File: 2014/1778

Tuesday, 21 April 2015

**RE: BCA Assessment – DA Submission R4.0
Taronga Zoo Sumatran Tiger Adventure**

2 EXIT BUILDING - SECTION
1:100

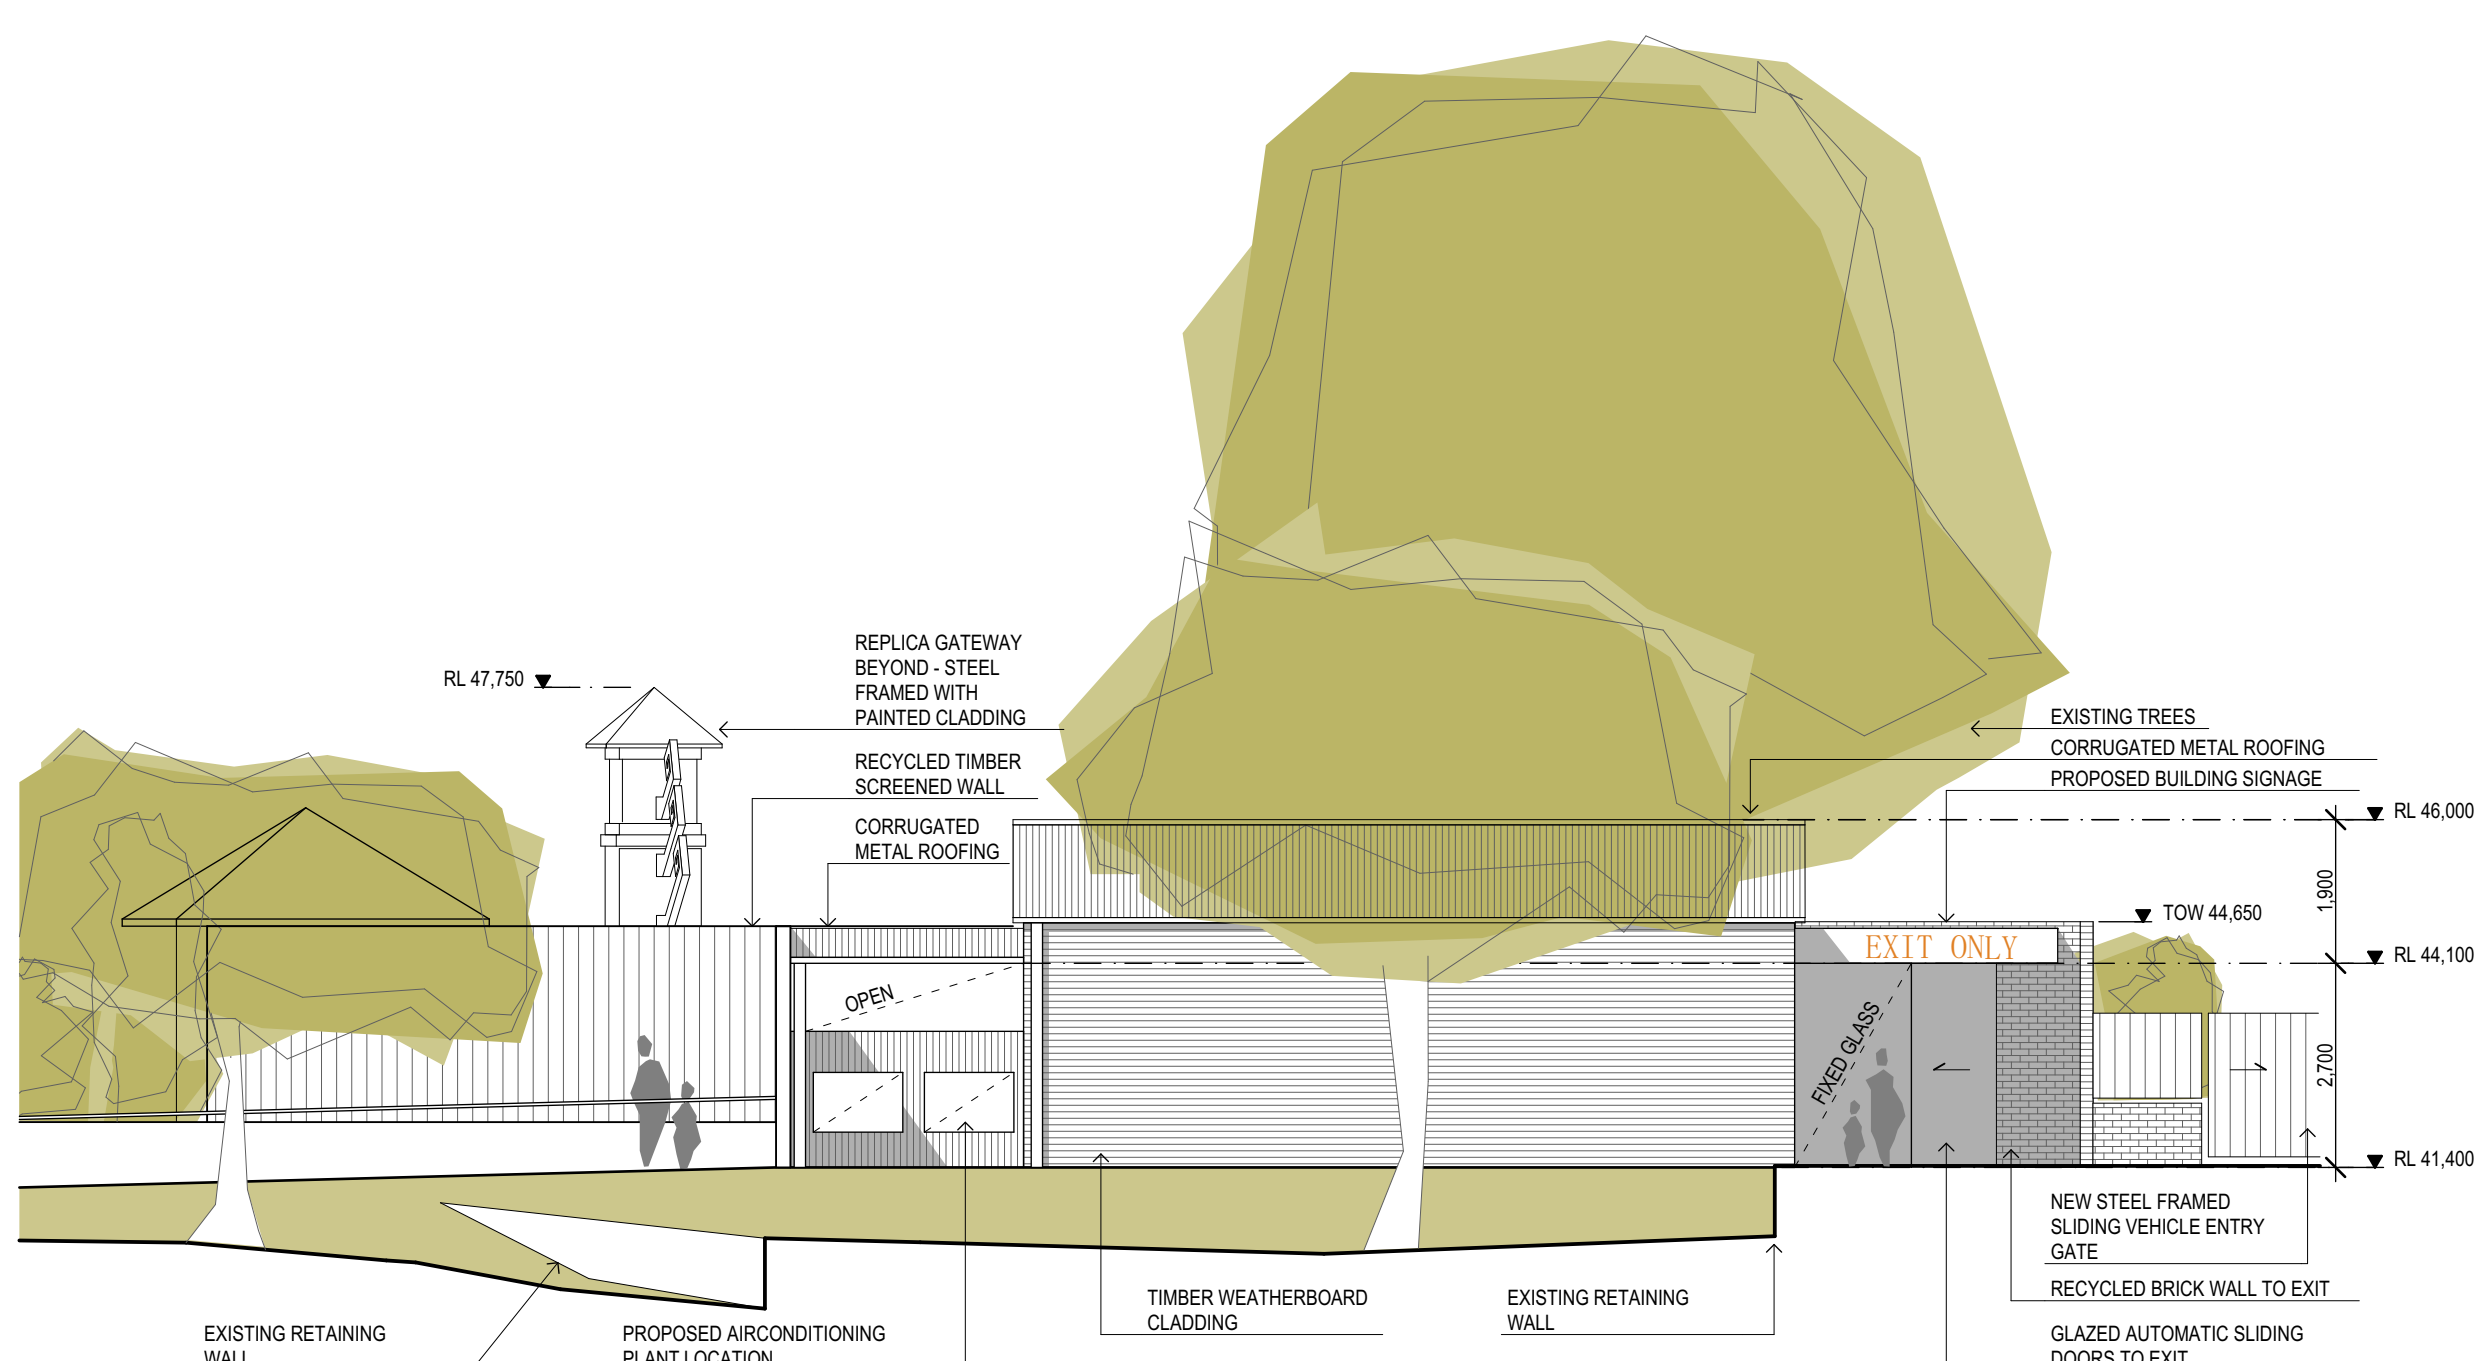
- Clause D2.19 requires the automatic sliding doors to the entry and exit to open automatically if there is a power failure to the door and have the capacity to be opened manually under a force of not more than 110N if there is a malfunction or failure of the power source.
